Town & Country Planning Act 1990 (as amended)
Town & country Planning (Development Management Procedure) (England) Order 2015
Application for Planning Permission for Works or Extension to a Dwelling

Development Two storey side extension & porch with pitched roofs.

Location 56 Chanctonbury Road Rustington

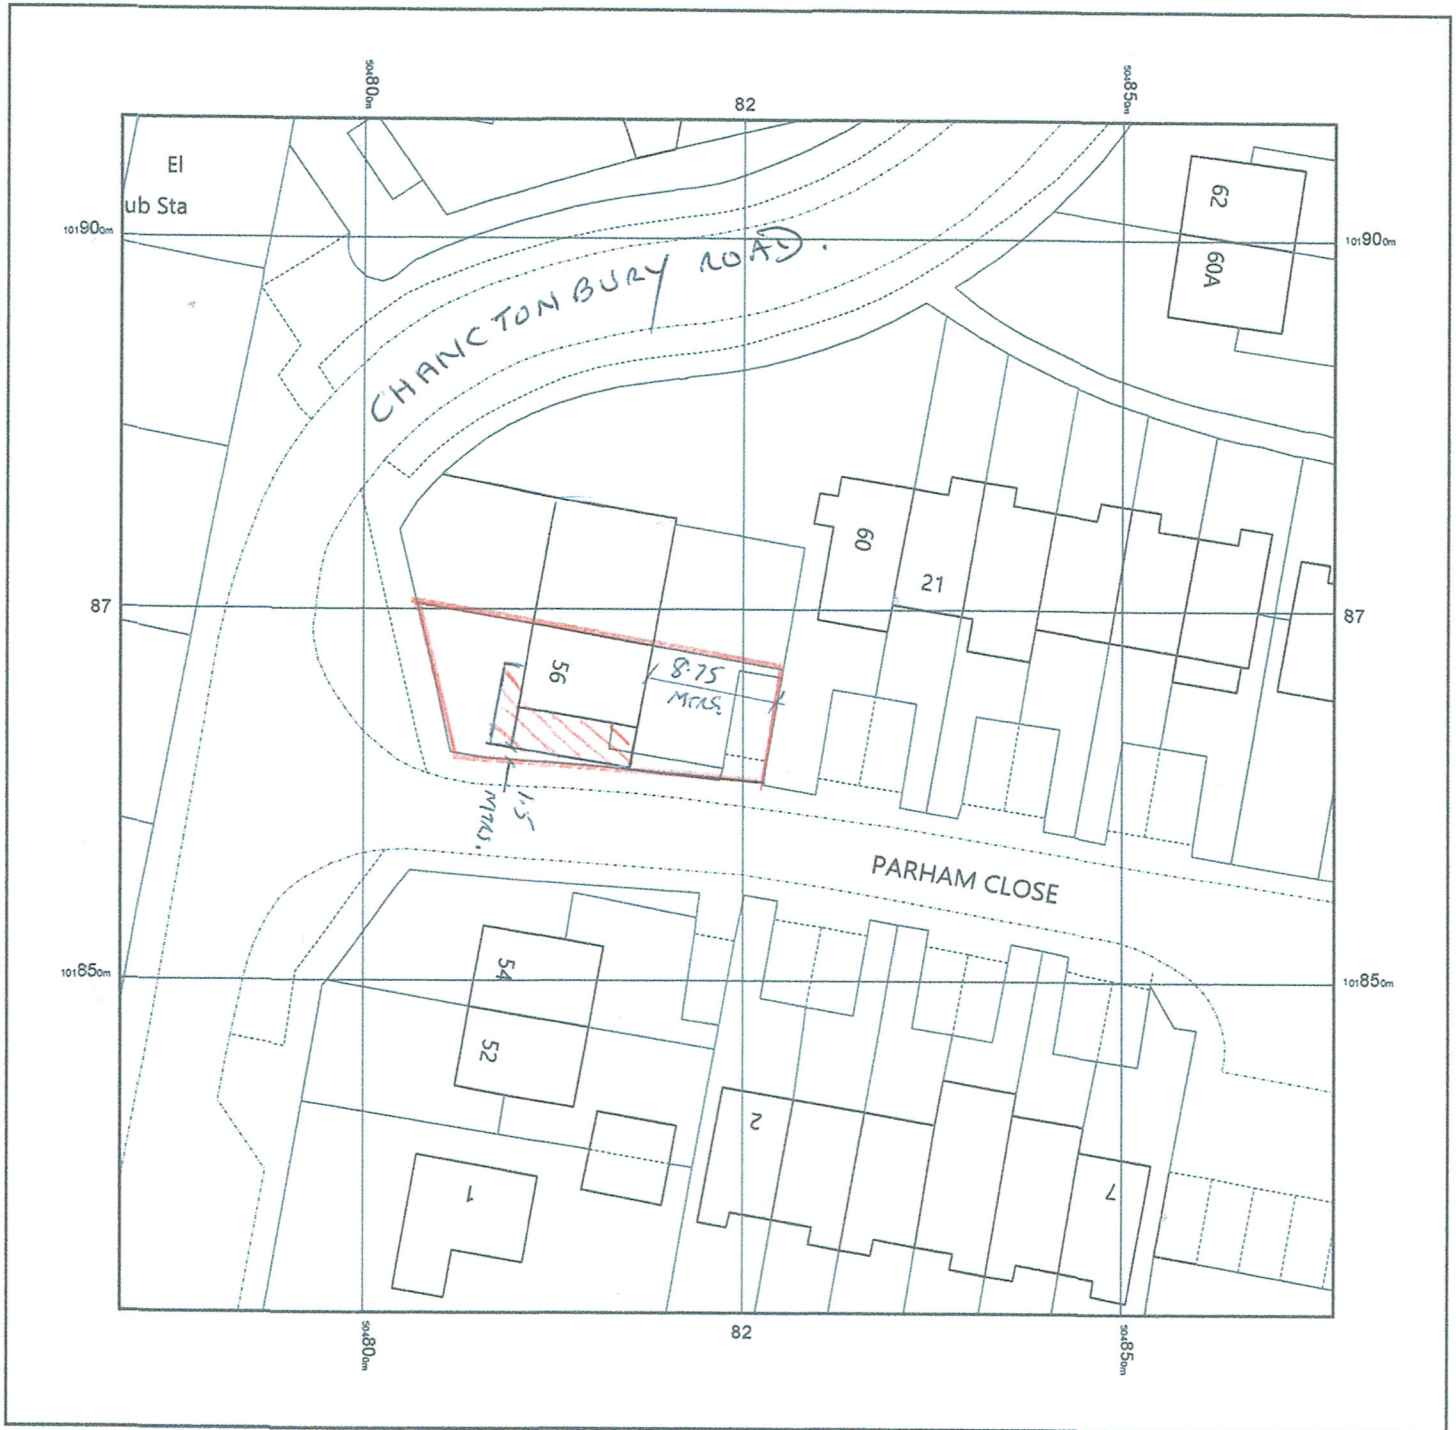
The red edge on the location and block plans do not accord. Either ensure the red edges are the same or take the red edge off of the block plan.

Proposed First Floor Plan

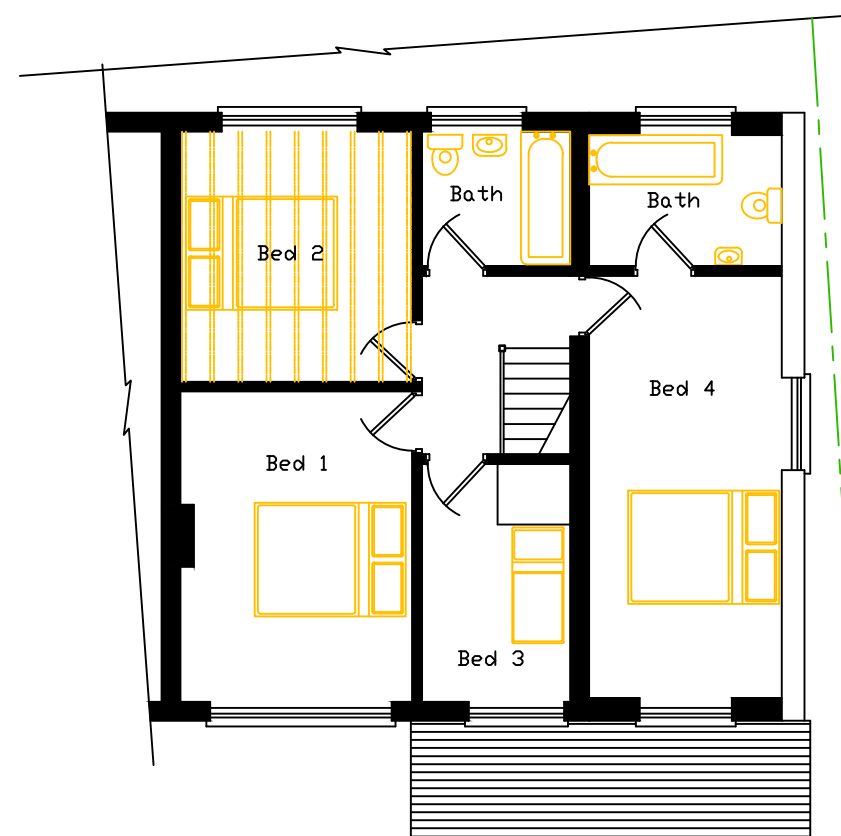
The proposed first floor south elevation and floor plan do not accord. Please amend accordingly.
